COUNCIL SUBMISSION TO MODIFIED STATE SIGNIFICANT DEVELOPMENT APPLICATION - SYDNEY OLYMPIC PARK HIGH SCHOOL (7 Burroway Road, Wentworth Point)

CITY OF PARRAMATTA COUNCIL SUBMISSION – PROPOSED SYDNEY OLYMPIC PARK HIGH SCHOOL - 7 BURROWAY ROAD, WENTWORTH POINT

SOPHS-WB-AR-DA1102

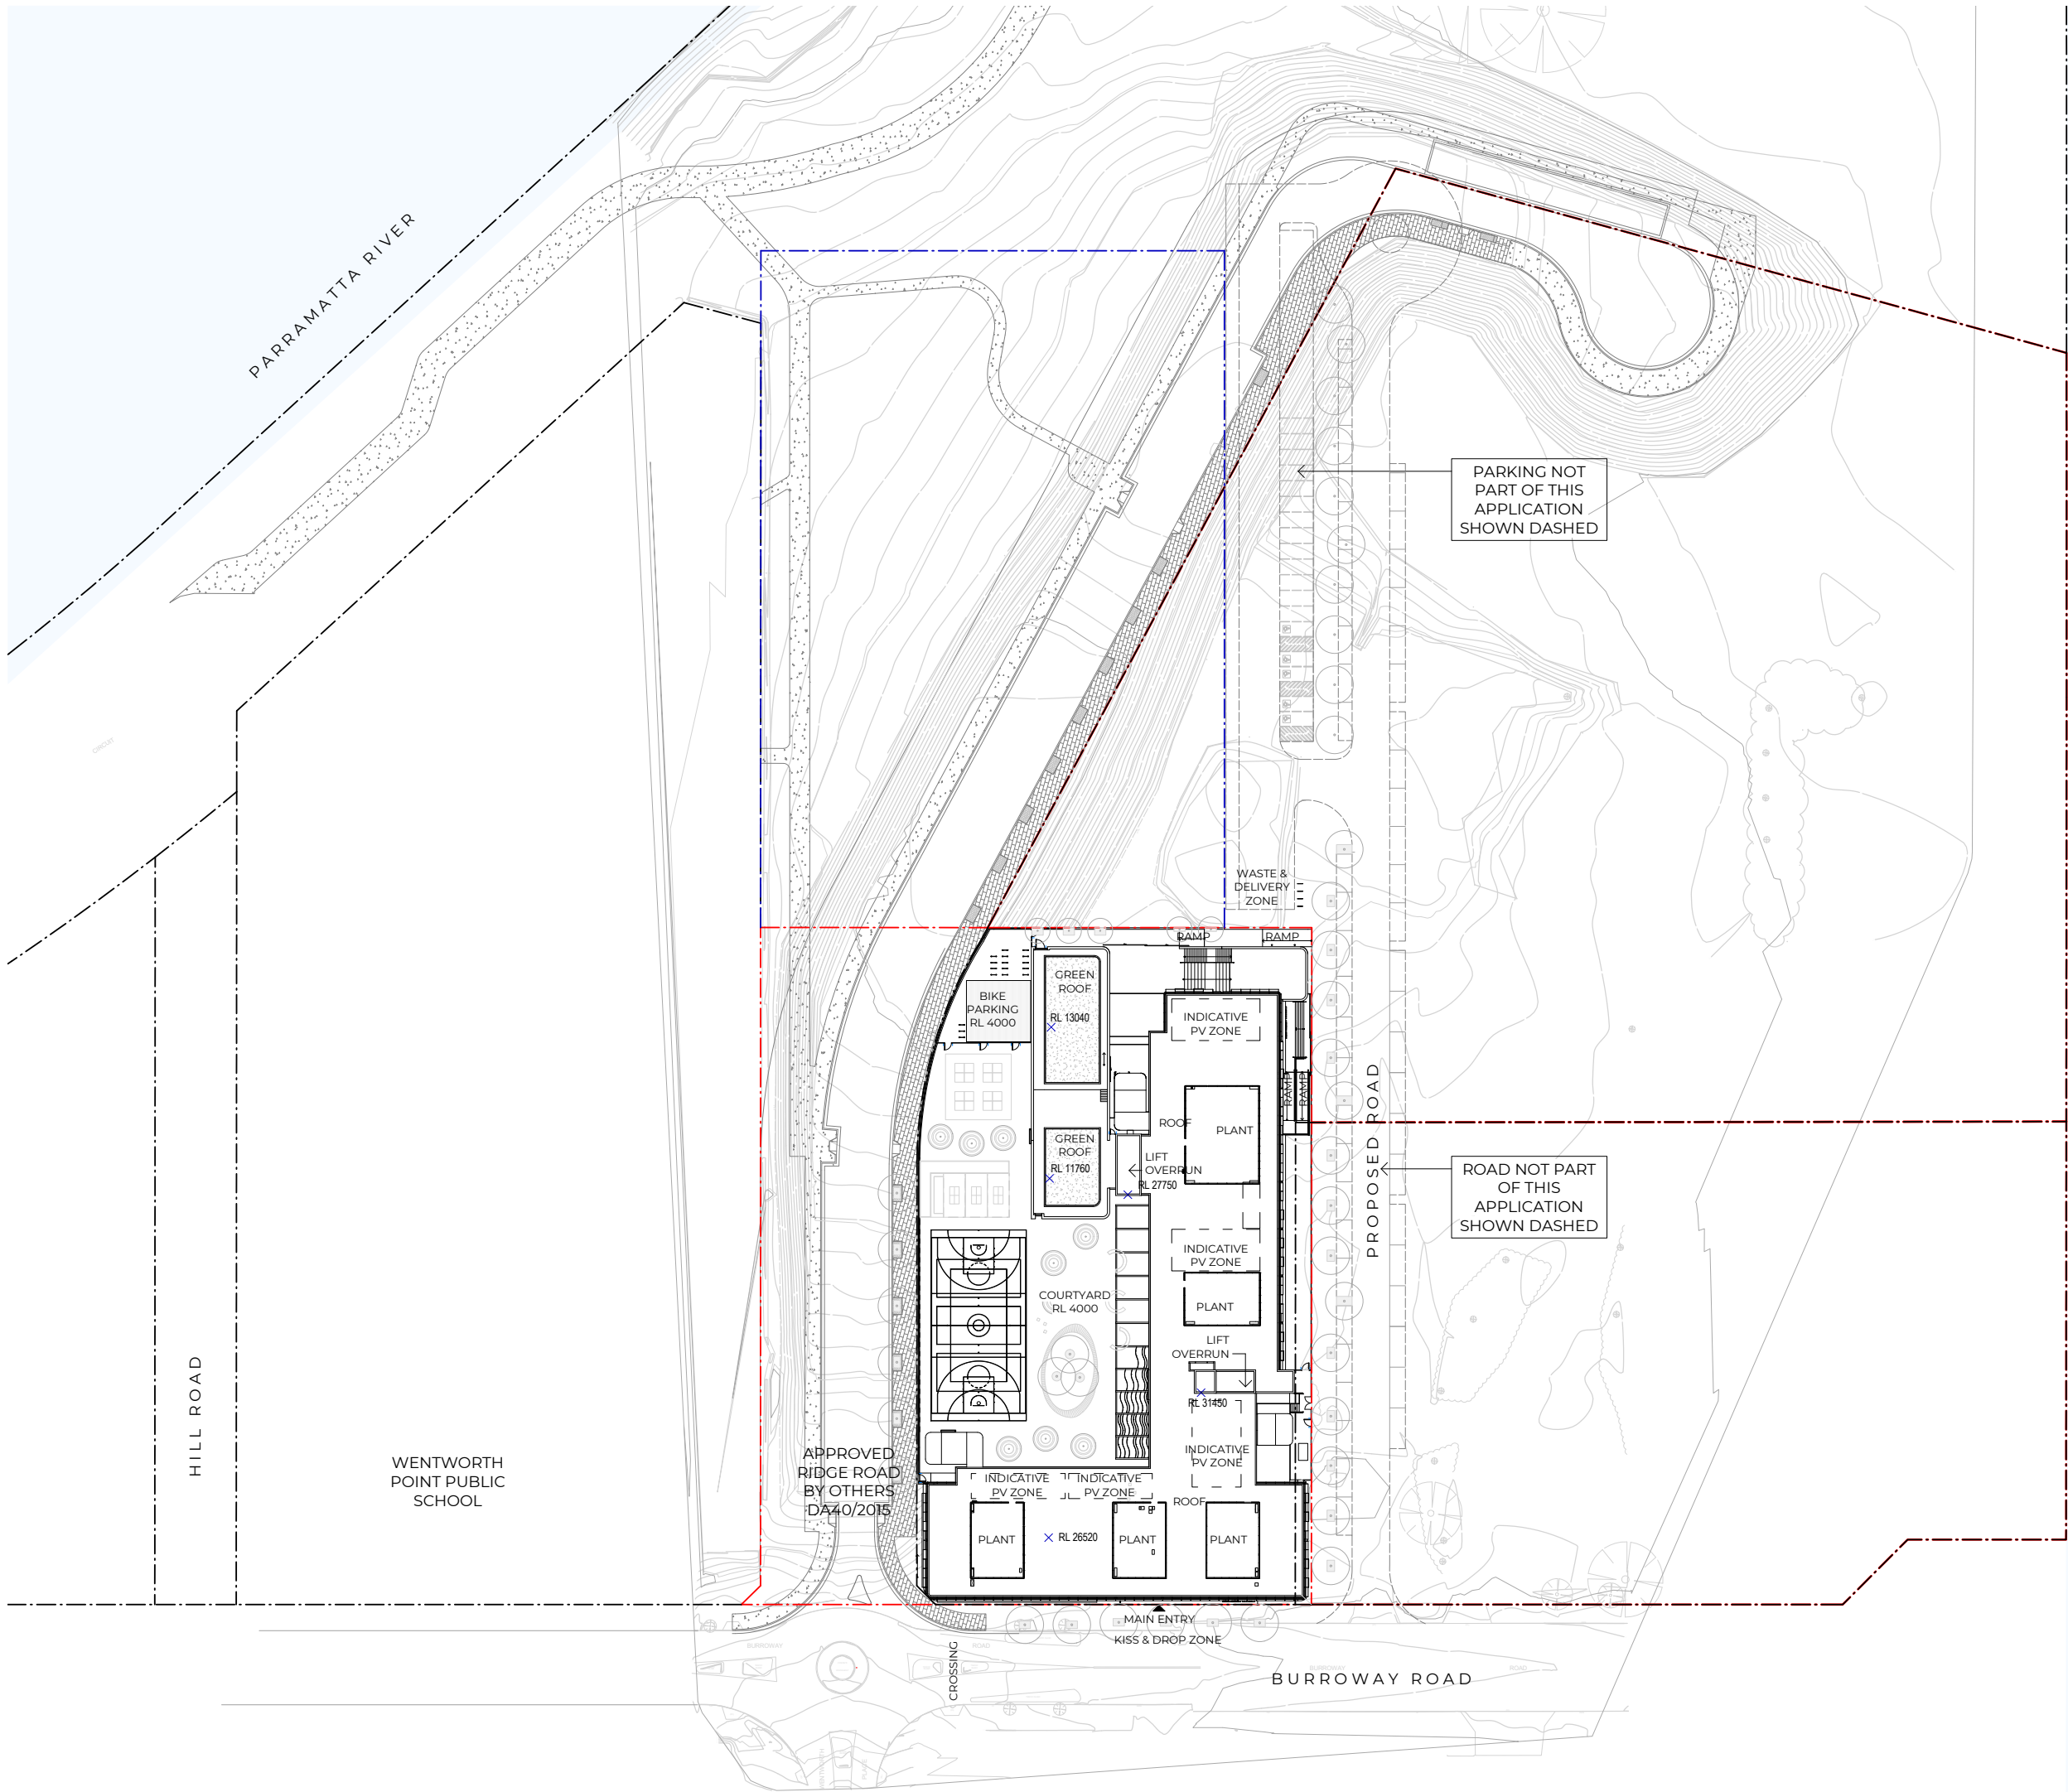
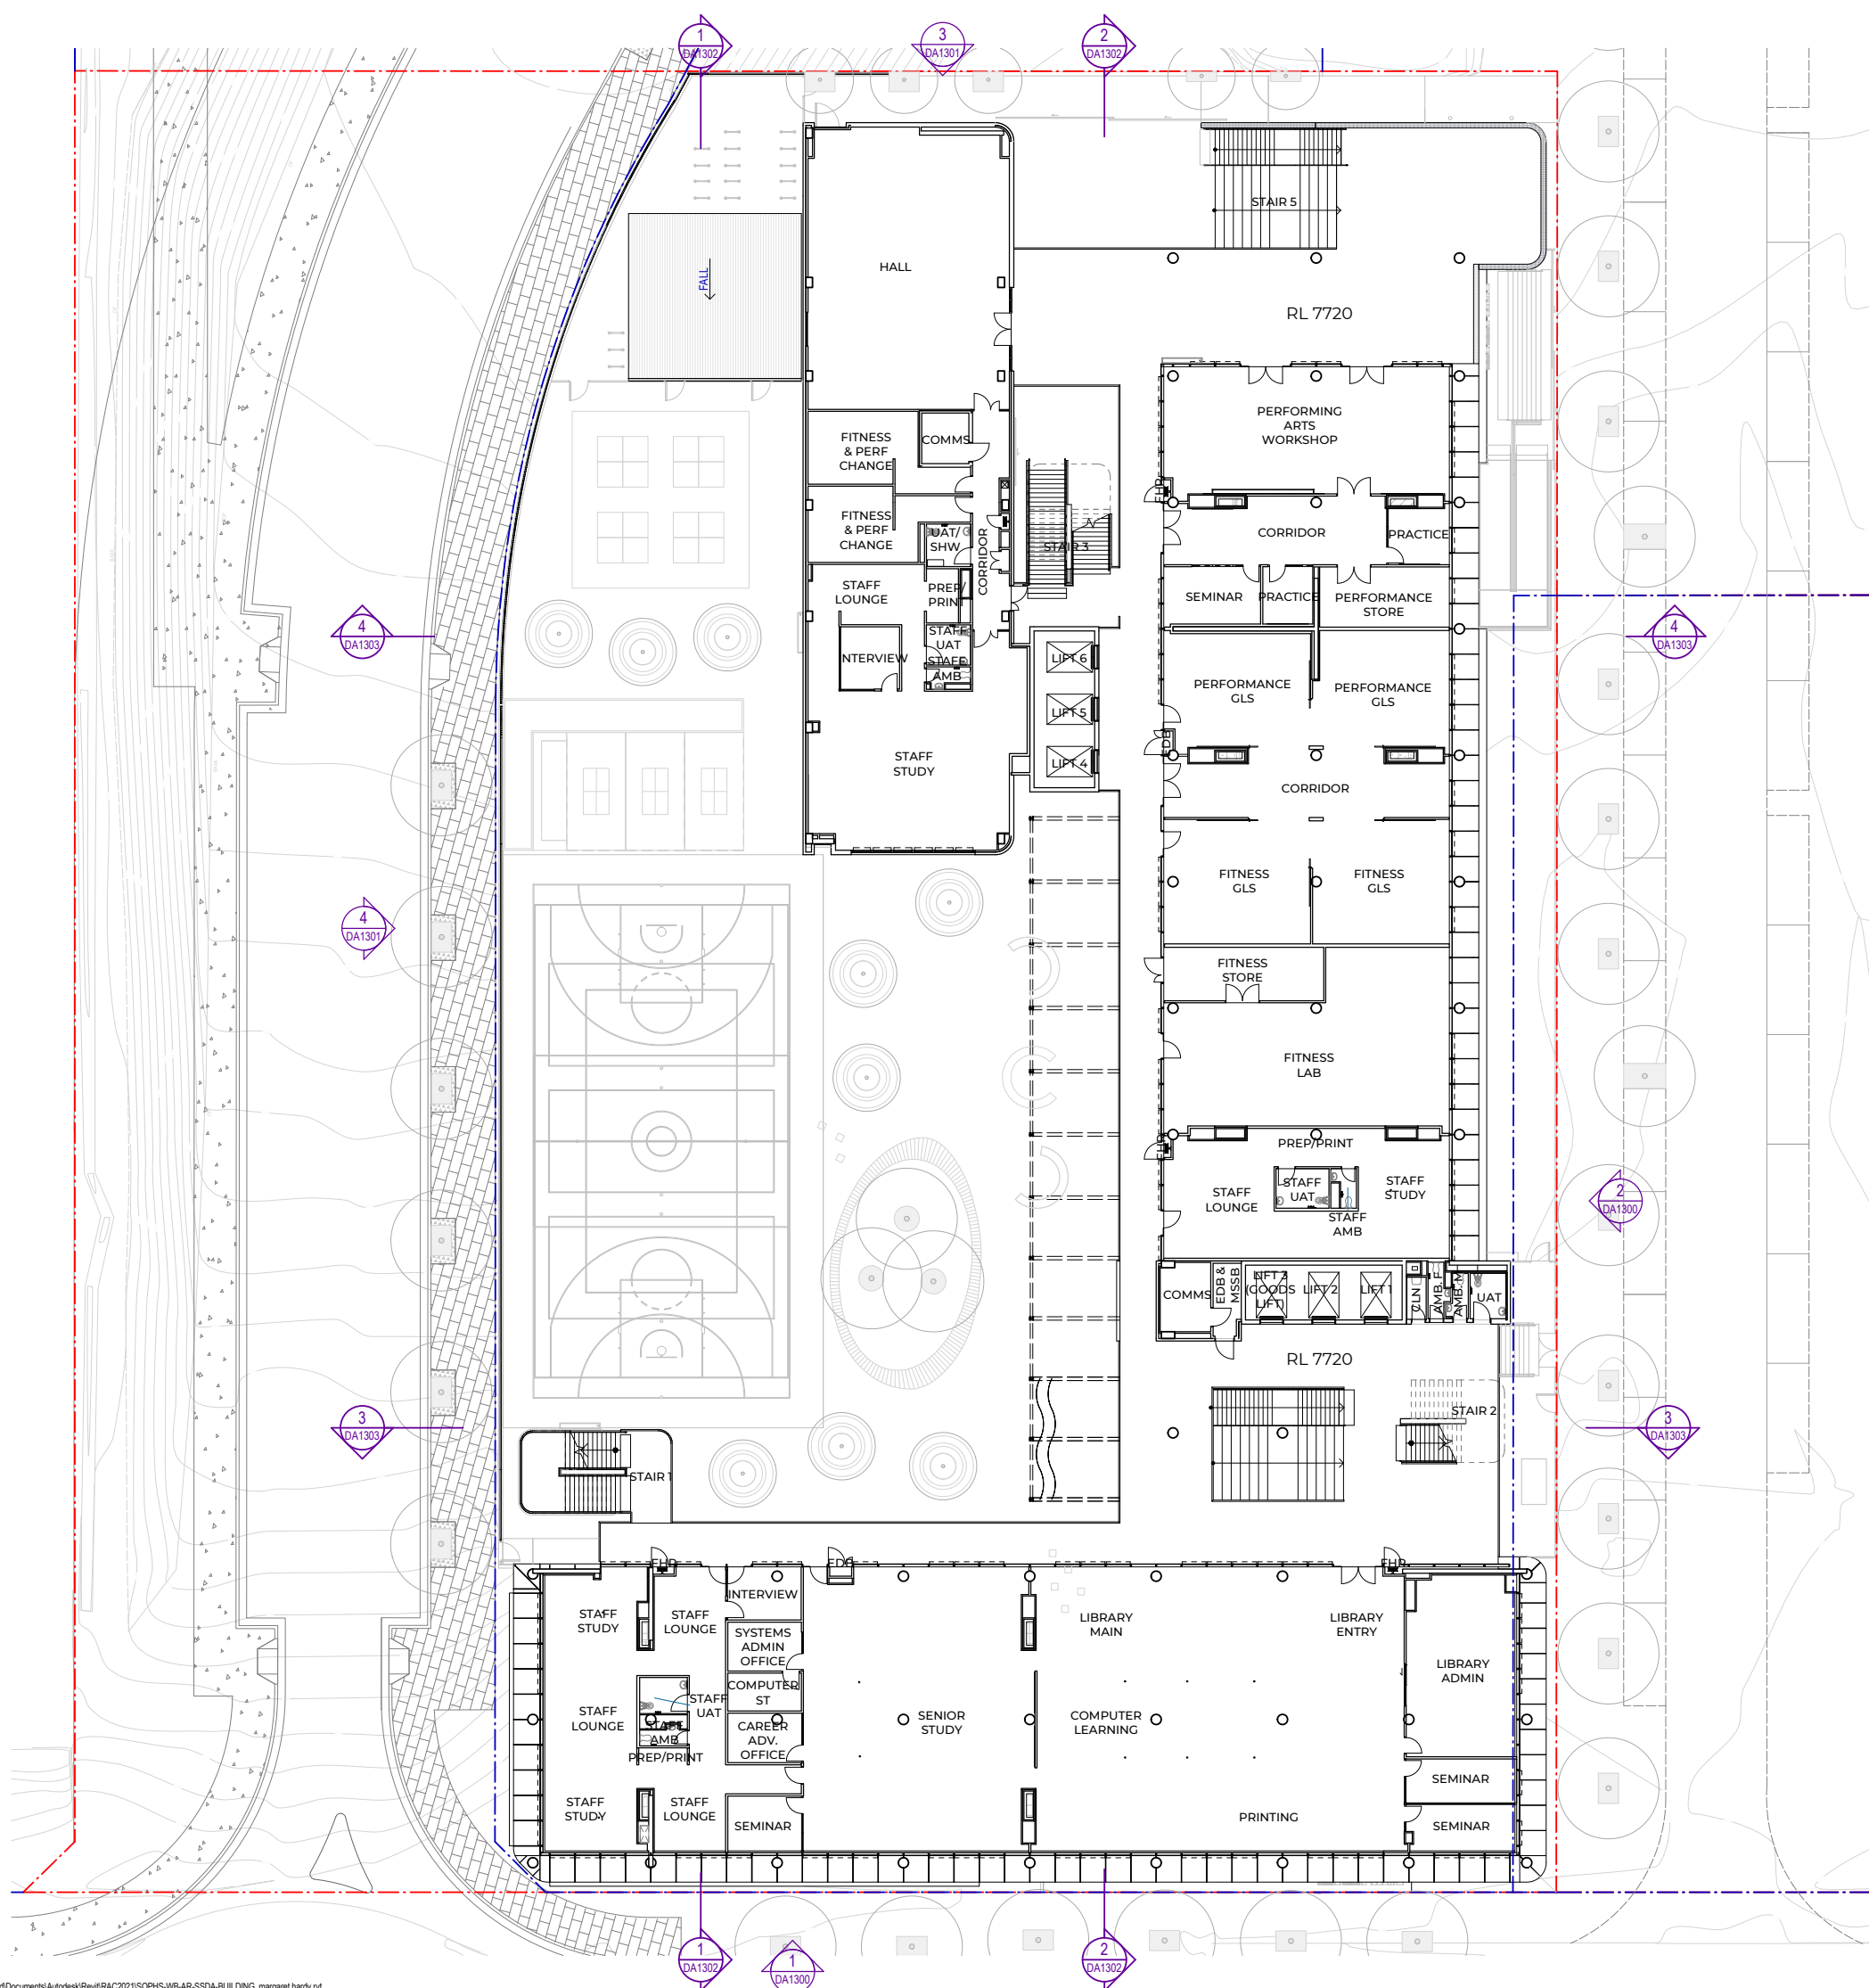
- The proposed setbacks do not reflect the required setbacks in according to the Wentworth Point DCP in either Burroway Road (6m) or the future local roads (3m).
- The street setbacks in the DCP must be reinstated to be consistent with neighbouring recent development and to support public amenity (including tree canopy).

- The proposed service area (pump room, comms room, etc.) at the corner of Burroway Road is not supported. This is the site's most prominent corner and should be given to more "active uses". The relocation of the main entry to this corner would facilitate its activation.

- No waste and loading area have been specified. This must be adequately addressed and form part of the proposal.
- The use of Burroway Road as kerbside waste collection and loading raises concerns with noise, smell, and impact to pedestrian access. It will also impact kiss and ride facilities.

- It is unclear how waste will be transported from the storage bins at the rear of the site to the street kerb. The appropriate route a mobile towing device would traverse should be considered.
